# Rezoning Transportation Analysis

Petition Number: 2021-160

General Location Identifier: 22348101

## Revision Log:

SECTION C

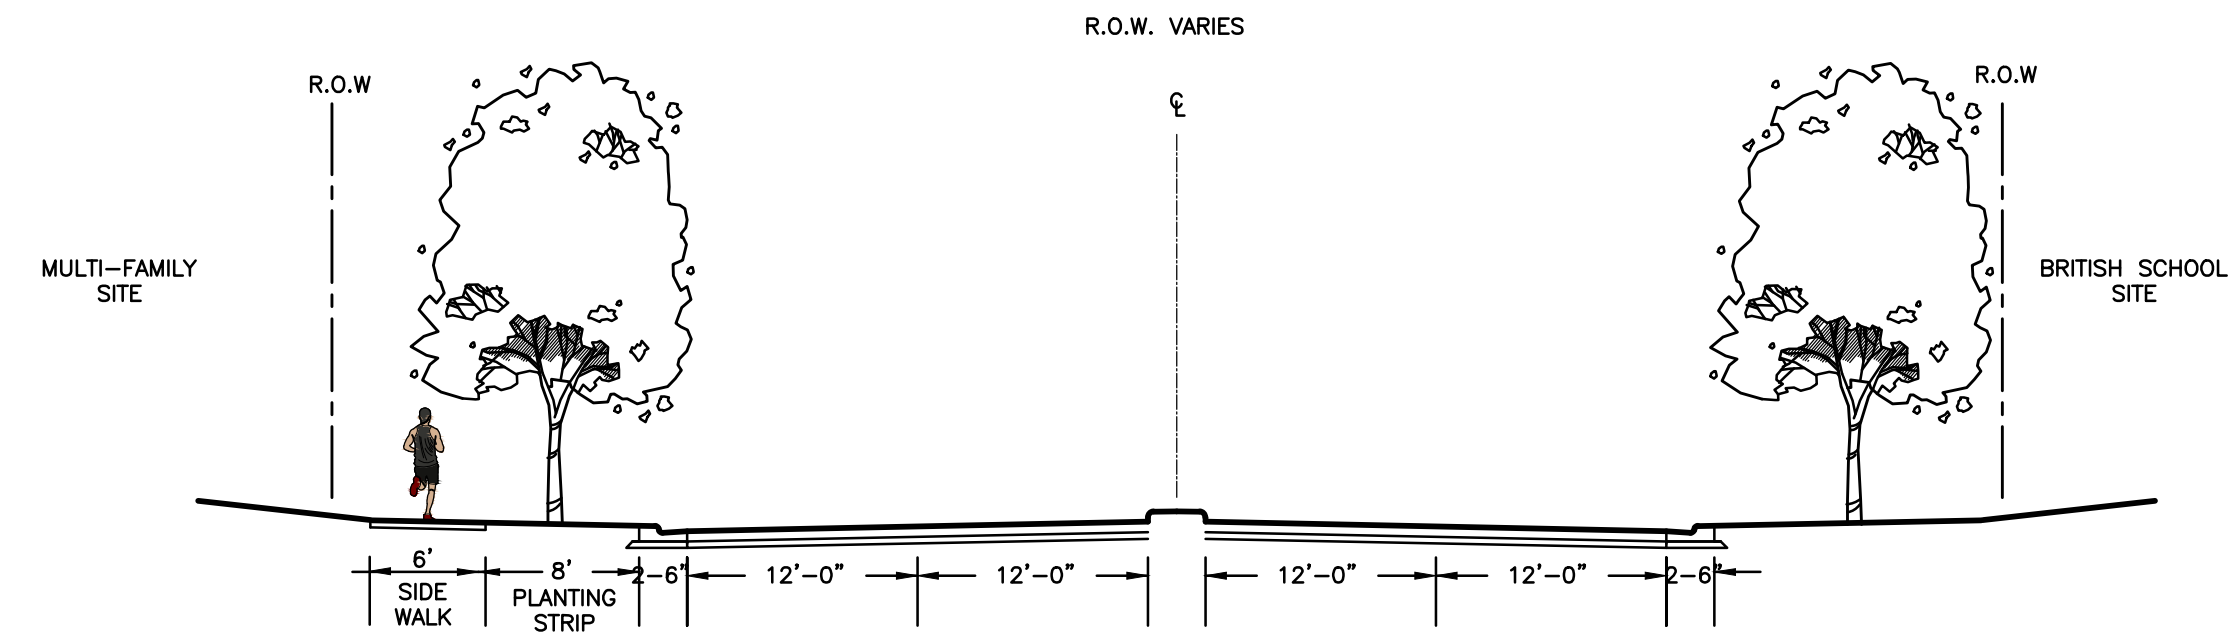
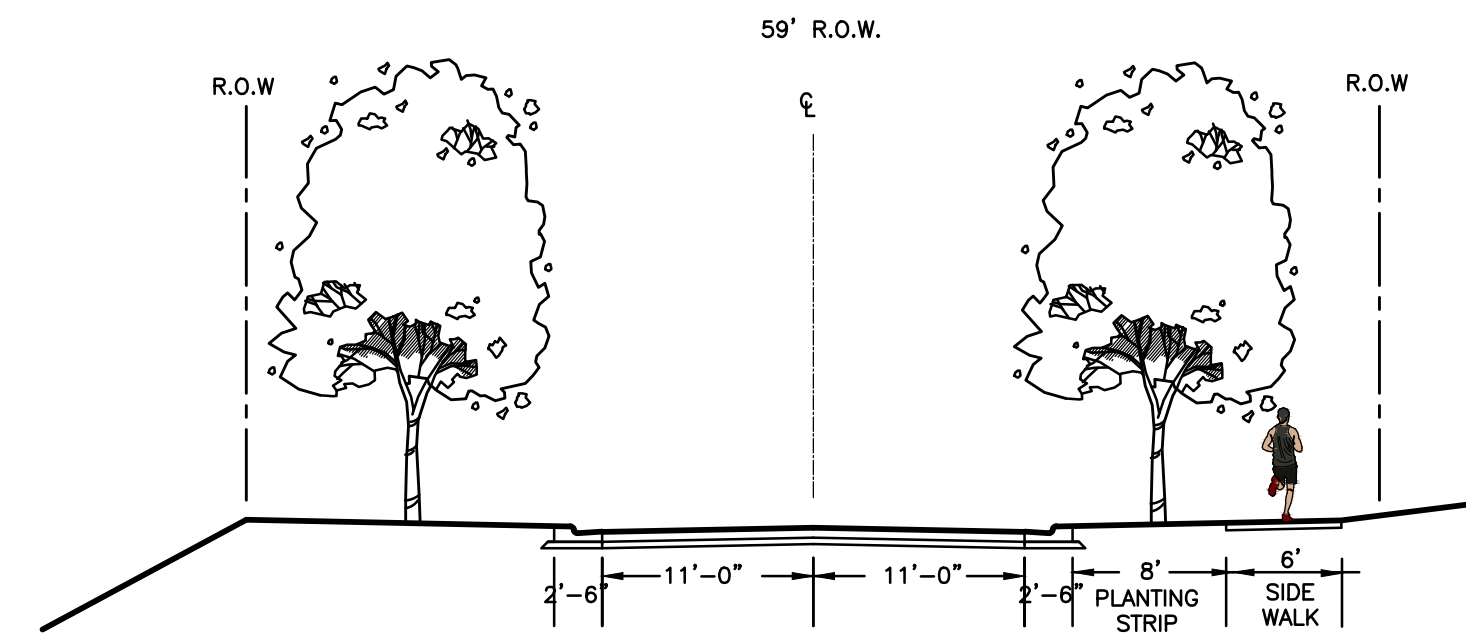
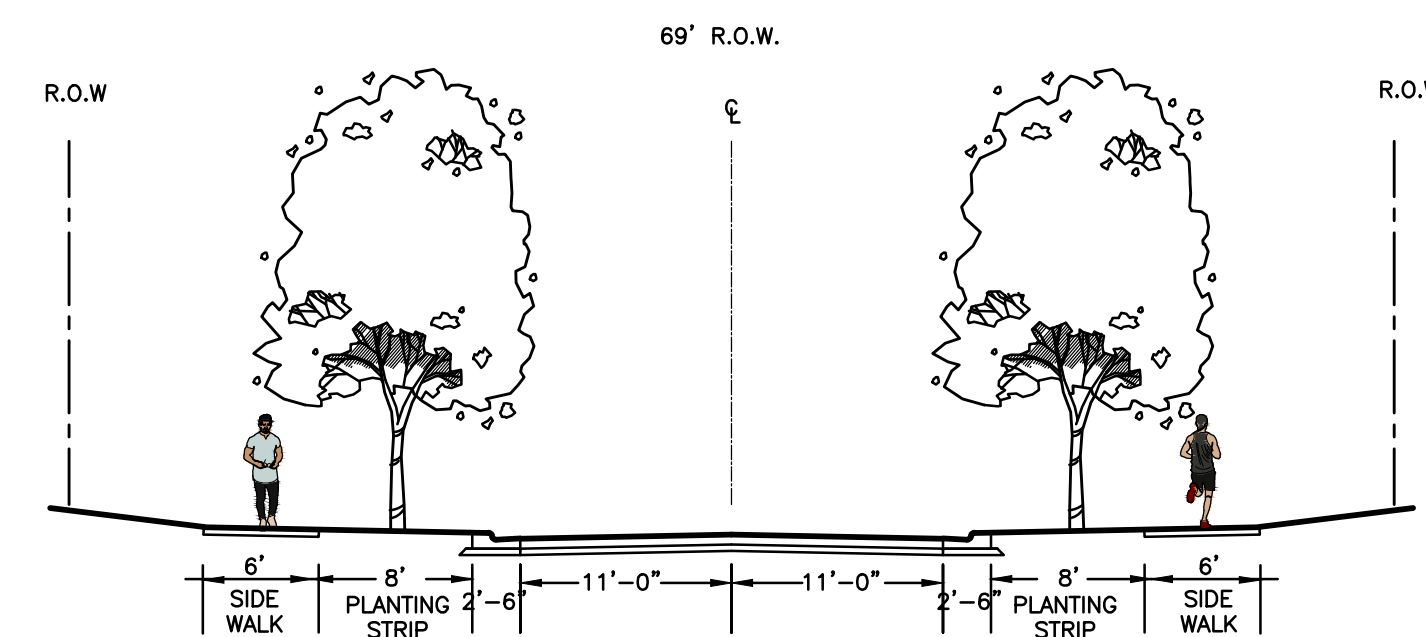
~~Revise site plan and conditional note(s) to commit to construct an 8-foot planting strip, and 6-foot sidewalk on all proposed public local roads per Chapter 19 and 20 and in accordance with the Charlotte Walks Plan.~~

Revise site plan and conditional note(s) to commit to installing accessible curb ramps at every intersection per PROWAG and ADA law. The site plan shall label and dimension both items from the back of curb and gutter and road centerline.
